RE: HOMESTEAD FILING 2 – PRELIMINARY ACCEPTANCE PUNCHLIST FOR FULL SPECTRUM DETENTION POND 1

The El Paso County punchlist from 11/28/2023 site walk identified a few inconsistencies within Pond 1 when compared to the approved construction documents.

**NORTH SAND FILTER EMERGENCY SPILLWAY**  
SCALE: 1"=2'

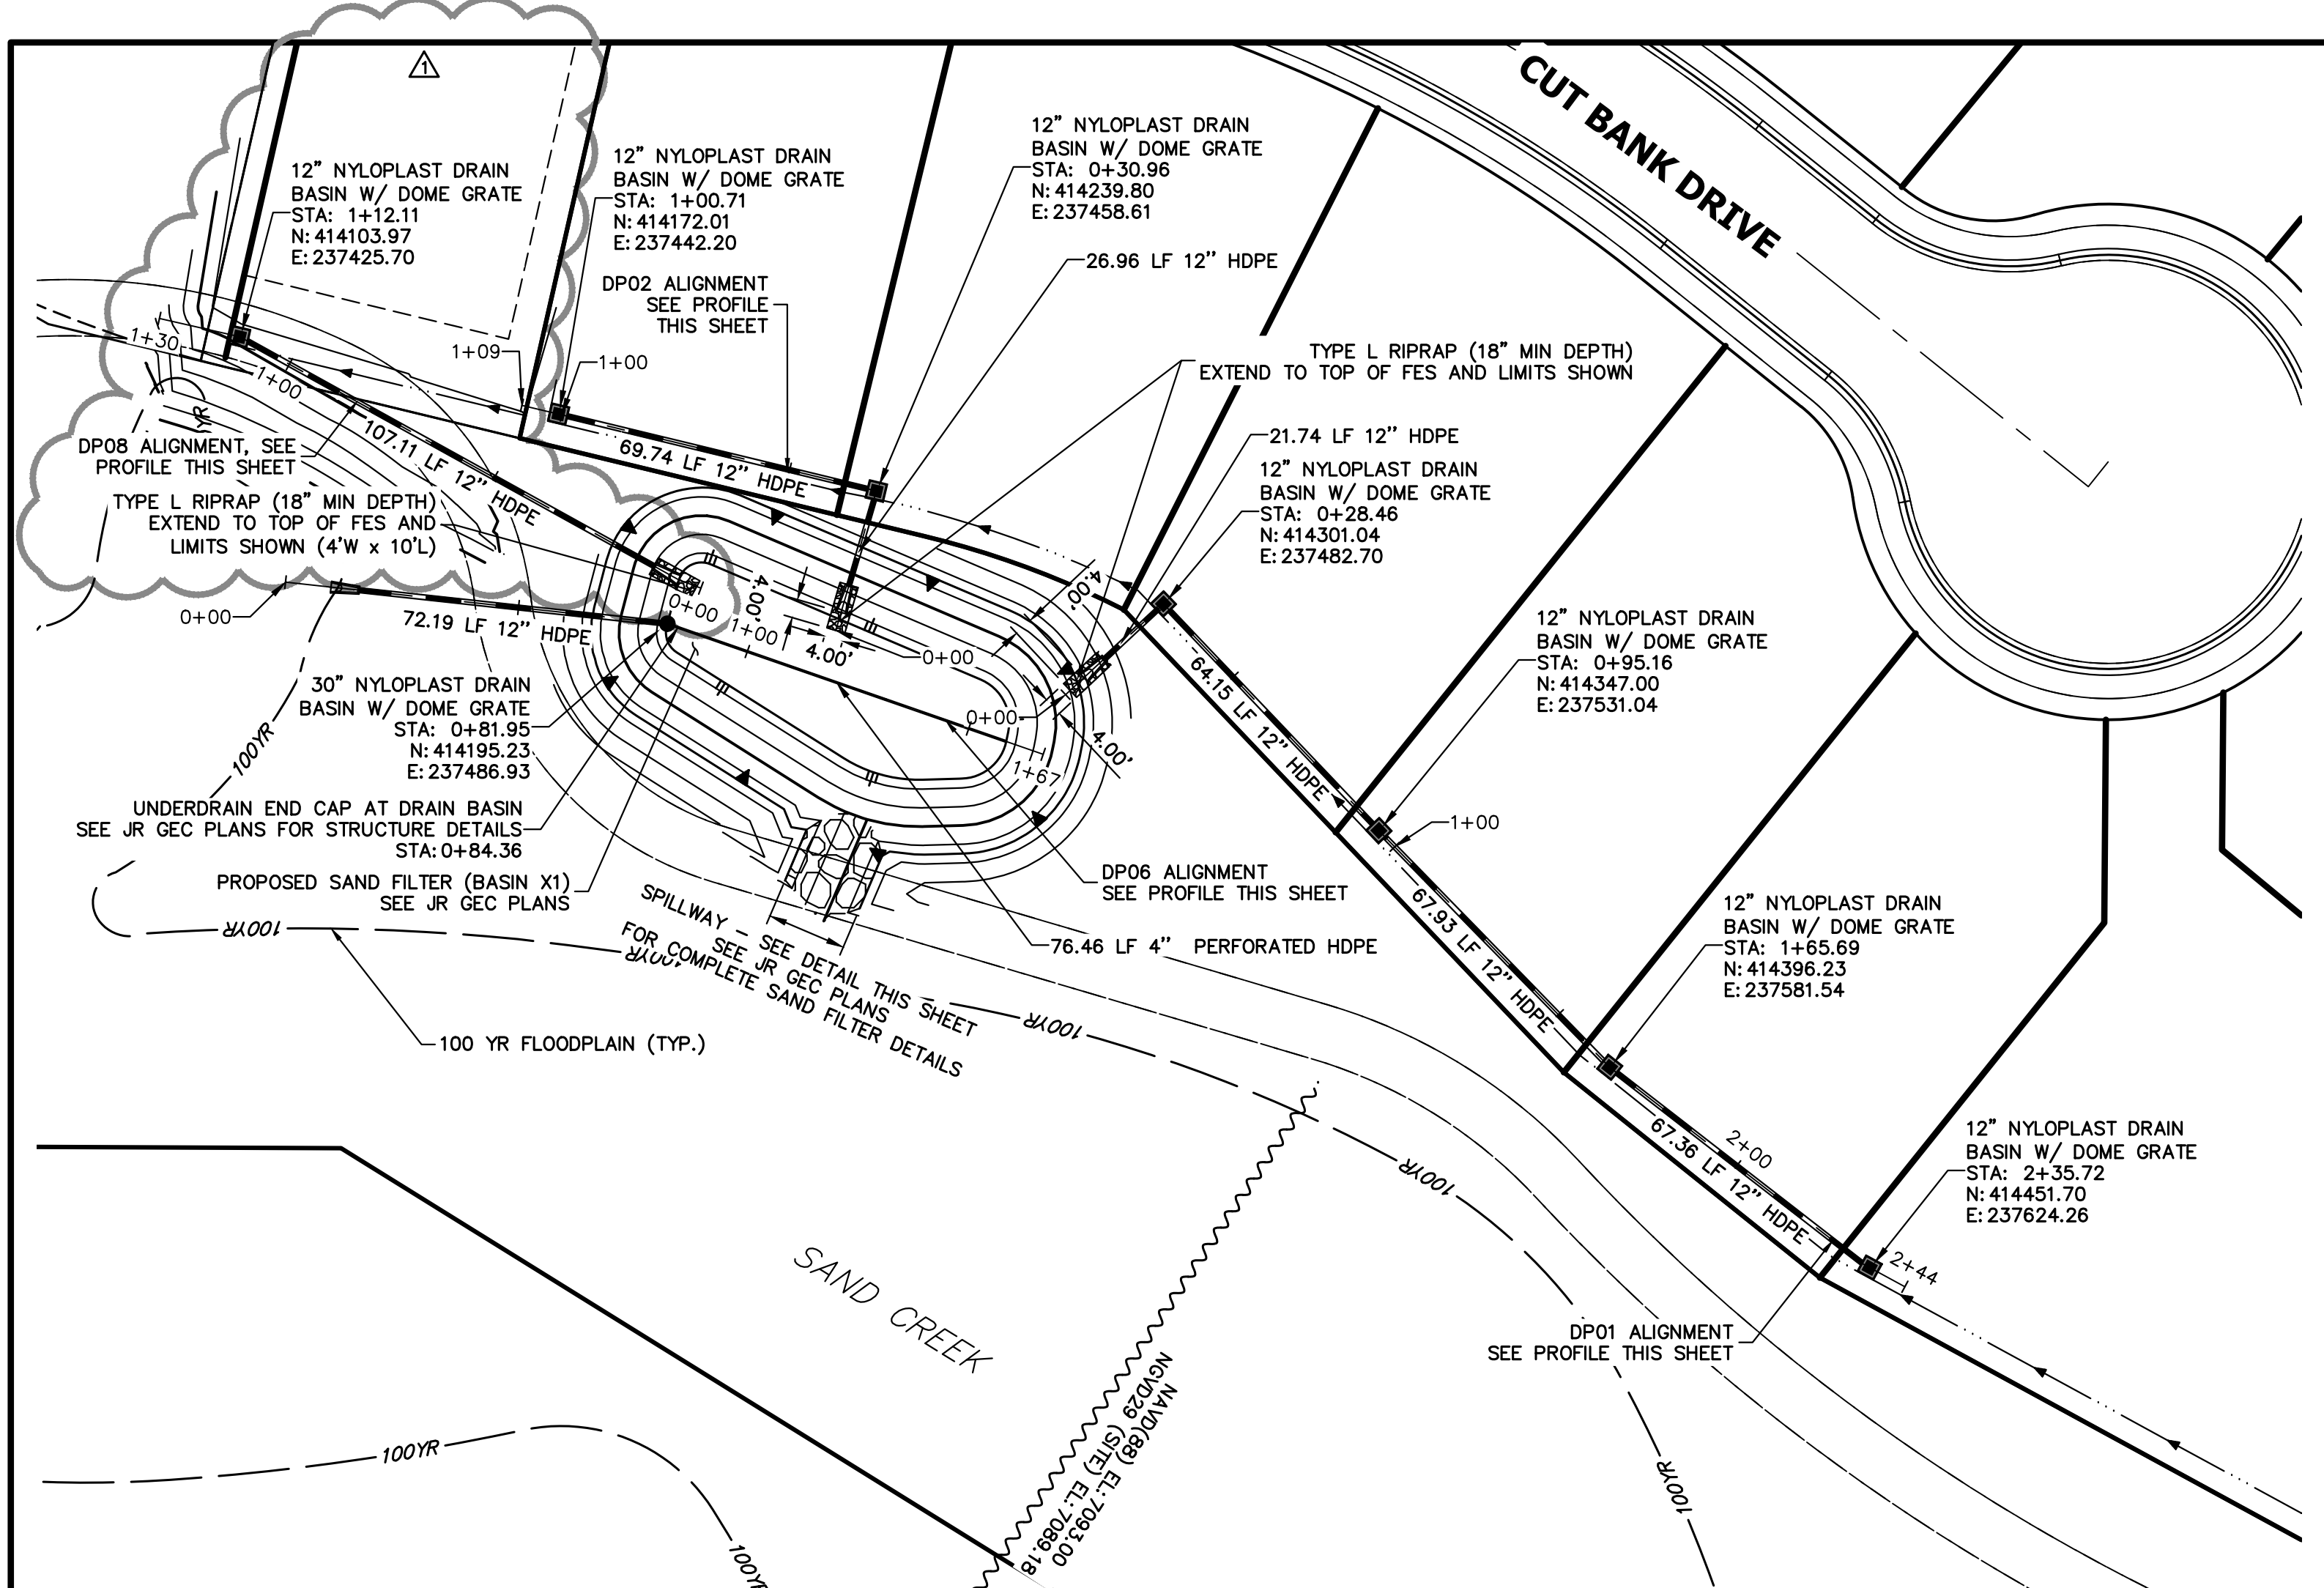
1. Spillway constructed with plain riprap instead of soil riprap

The reason for calling out soil riprap for the spillway protection is that soil riprap gives a finished look and can be revegetated, however; both clean riprap and soil riprap are acceptable erosion protection treatments for the spillway. Therefore, I recommend the clean riprap remain within the spillway.

FDS POND 1 EMERGENCY SPILLWAY AND RUNDOWN TO SAND CREEK CHANNEL
1"=10'

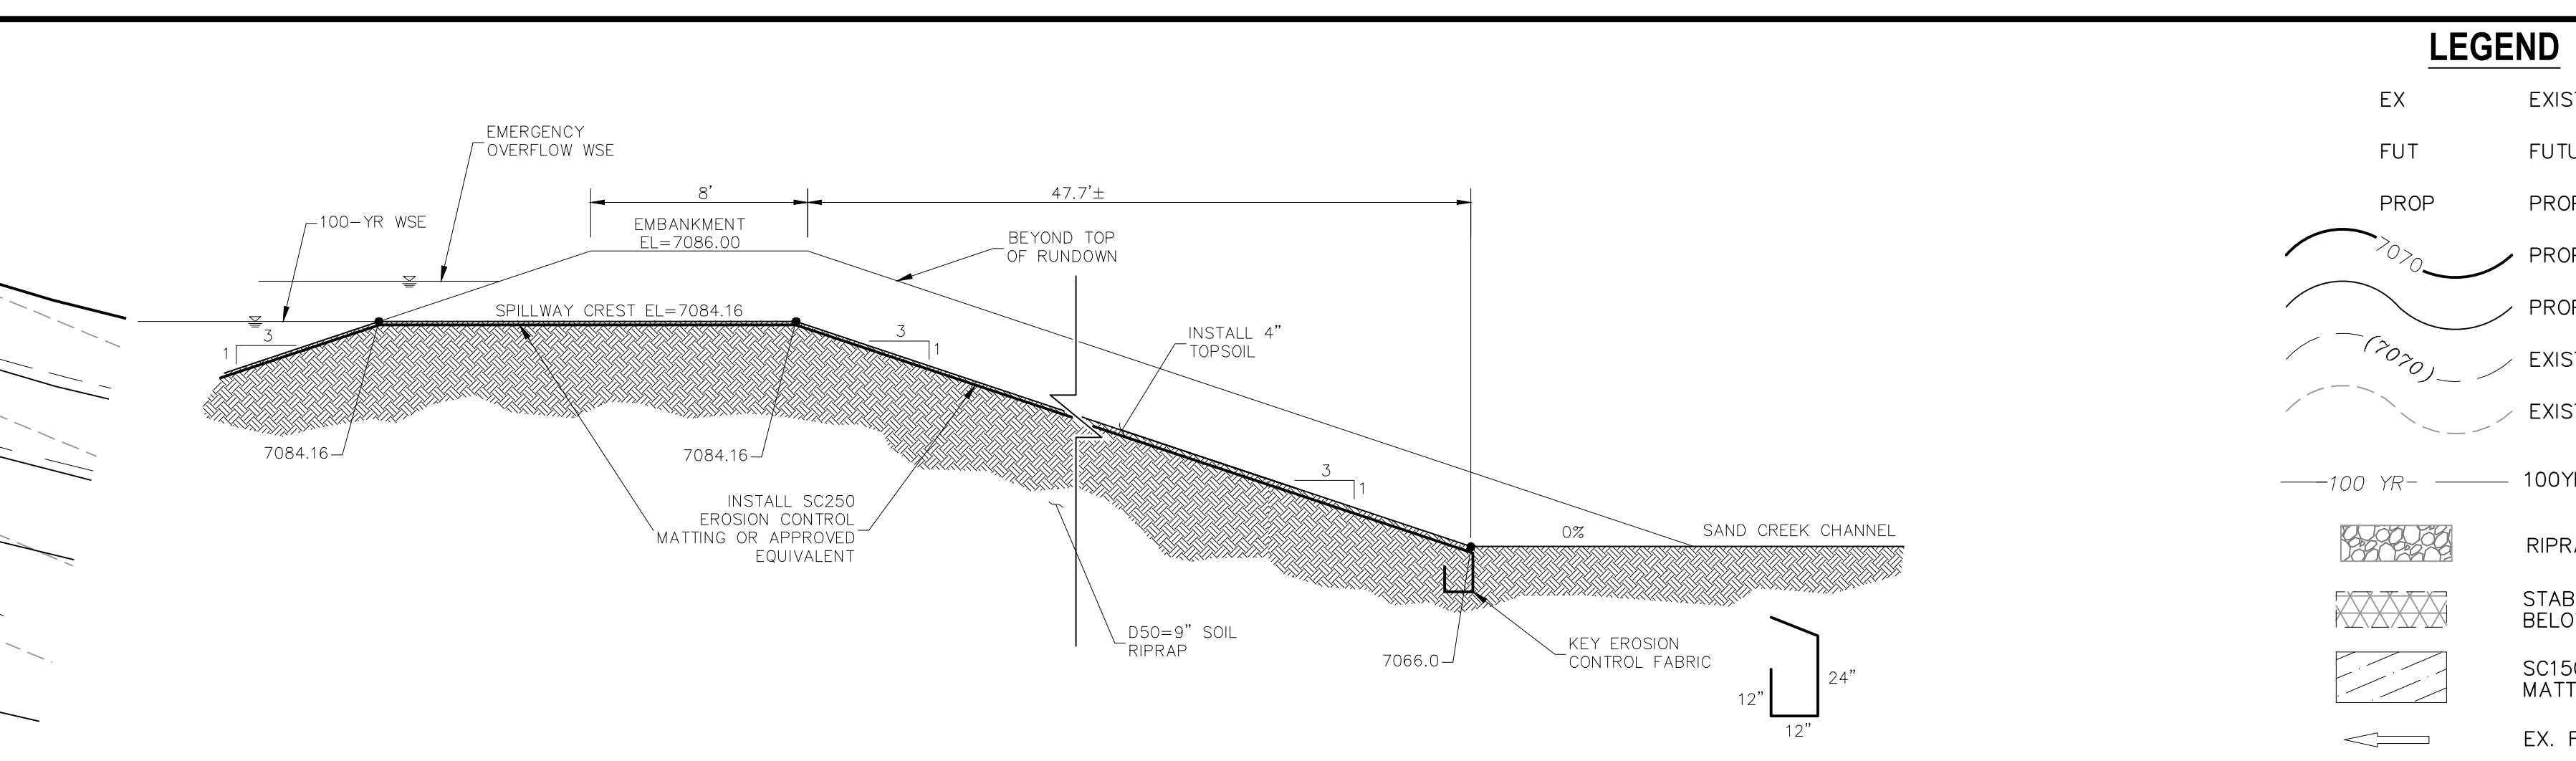
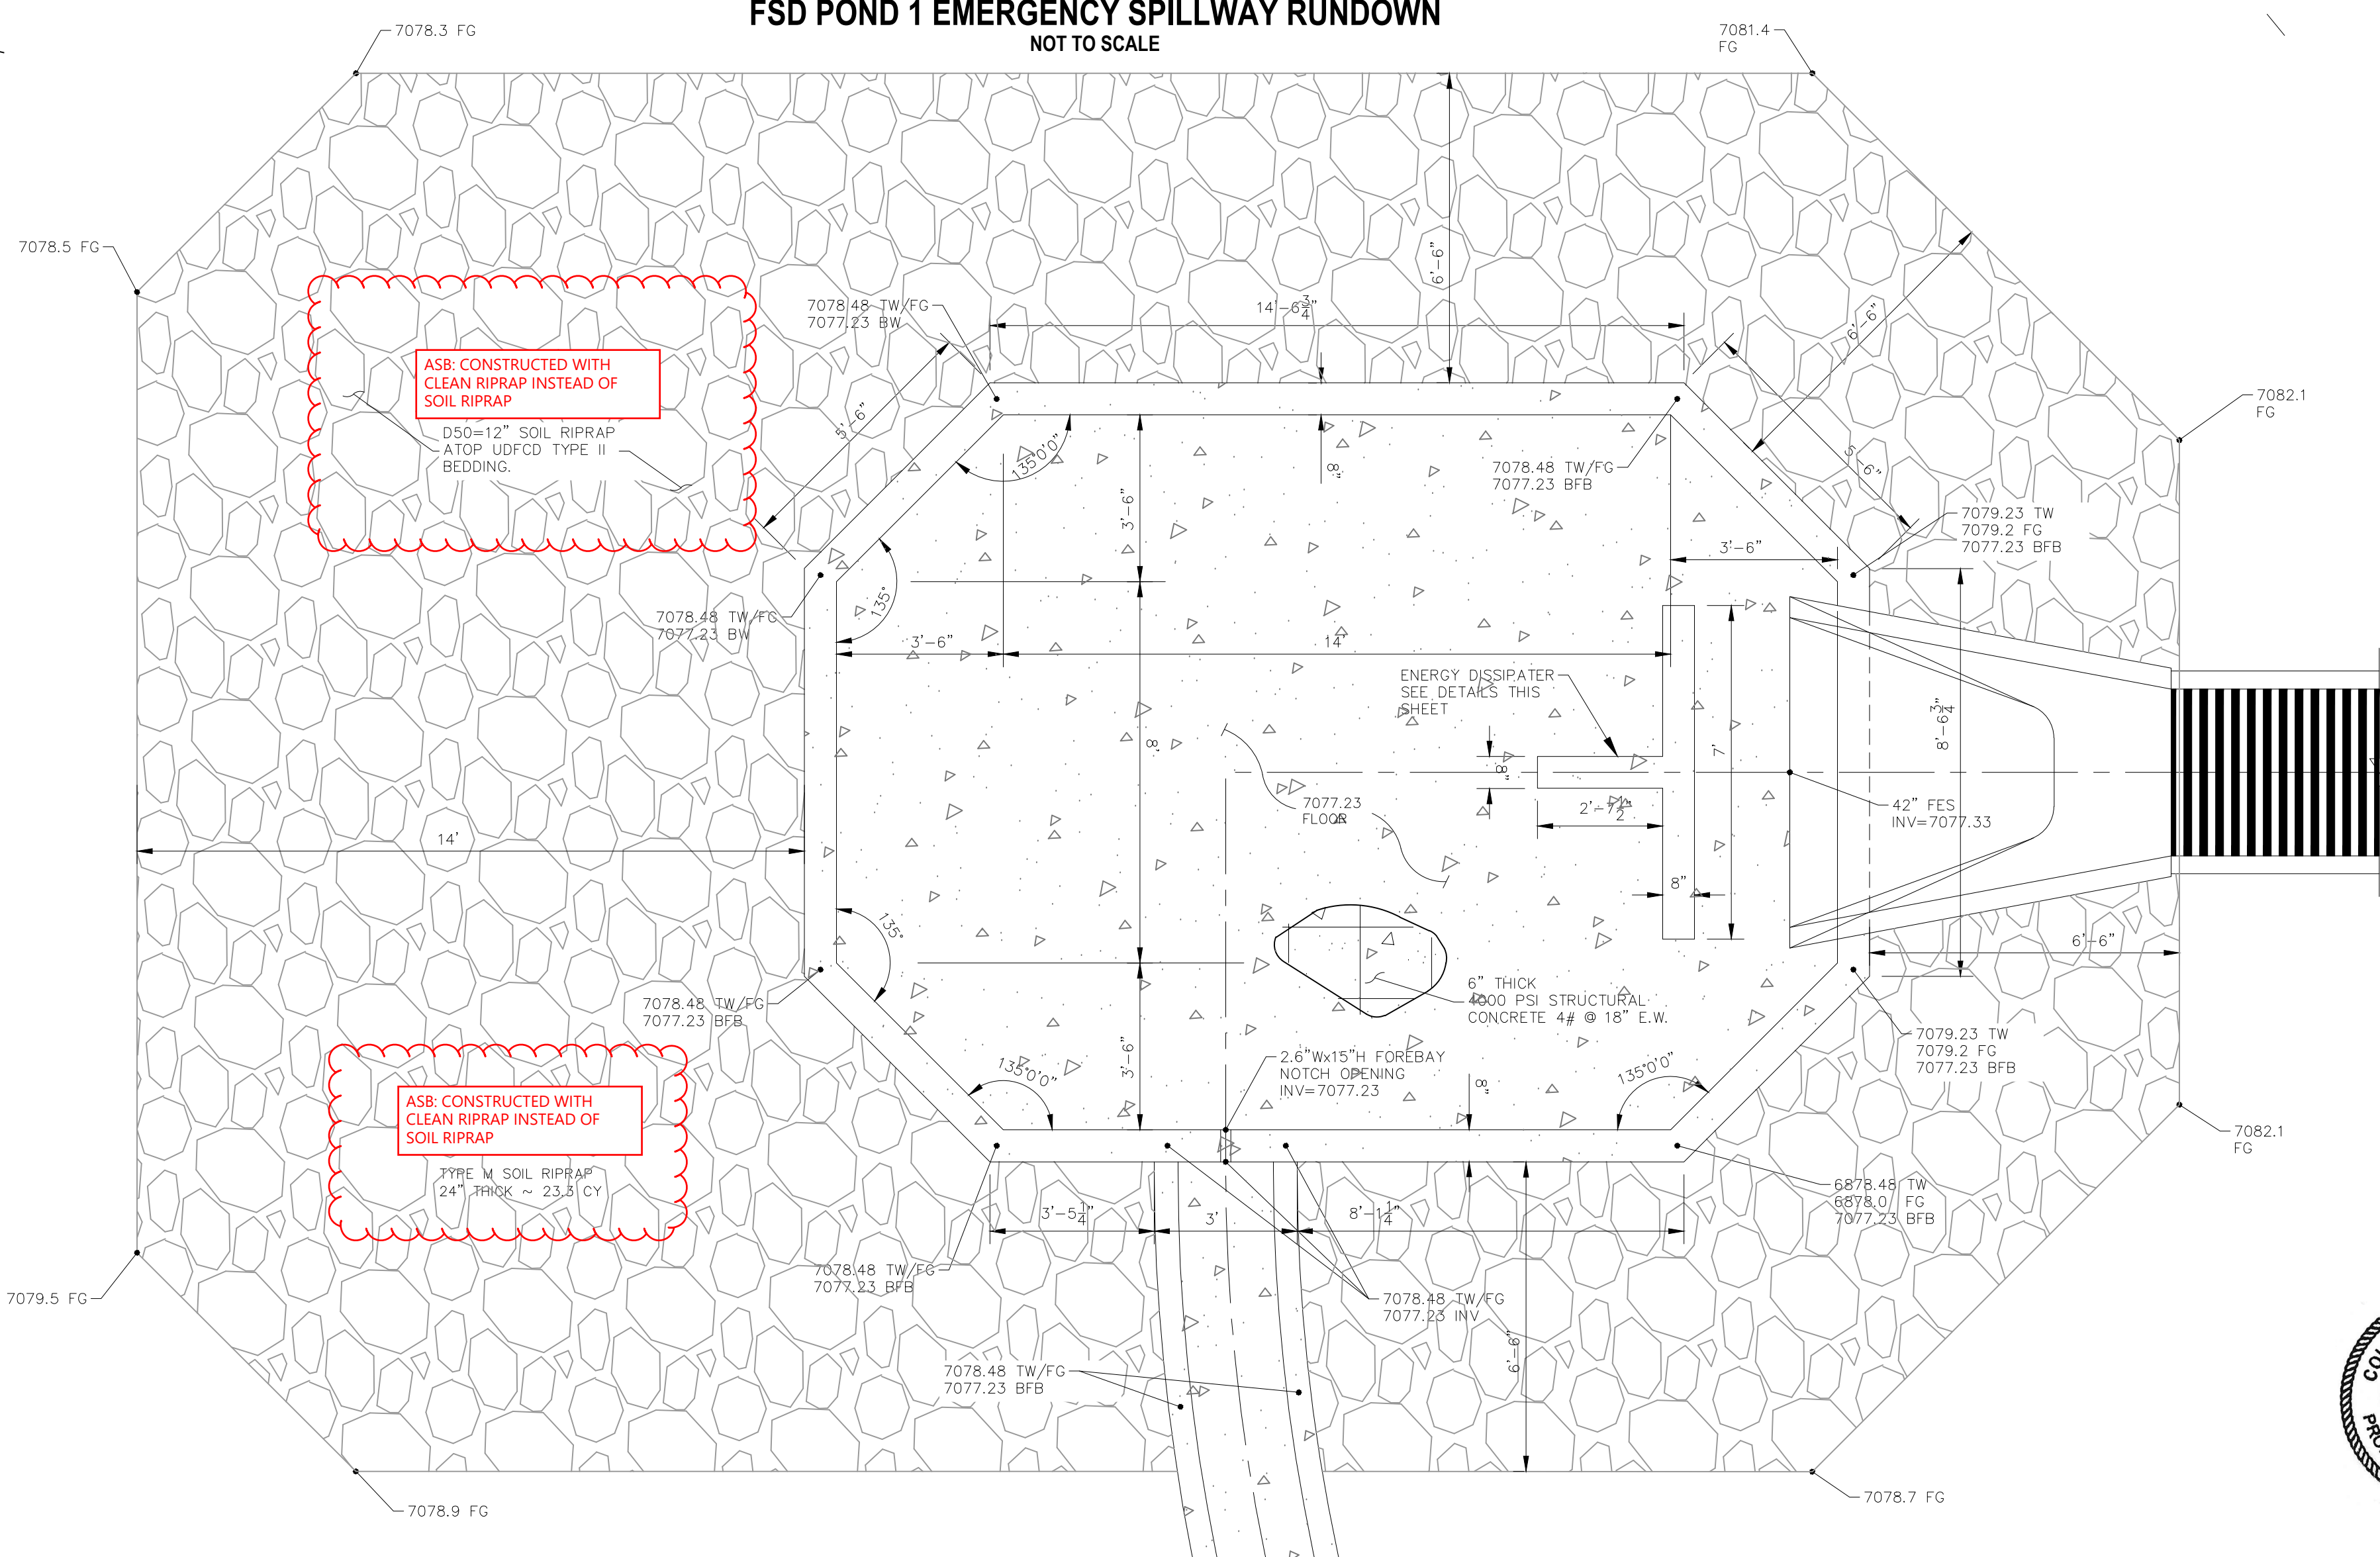
1. Micro screen installed with V-wire bars are horizontal and not vertical
2. Pond outfall not installed per plans. Plunge pool approved, 8' x 30' riprap pad installed.
3. Shown plan riprap around forebay, instead of soil riprap
4. Flat portion of Section A-A (spillway) is installed at less than 20 ft wide.

The spillway was proposed at 20' in the approved construction documents. However, it was constructed 16' wide. The UD-Detention 3.07 spreadsheet for Pond 1 has been updated with the 16' spillway width and confirms the spillway will pass the undetained 100-year flow with 1.0' freeboard. Therefore, I recommend the 16' spillway remain as is.
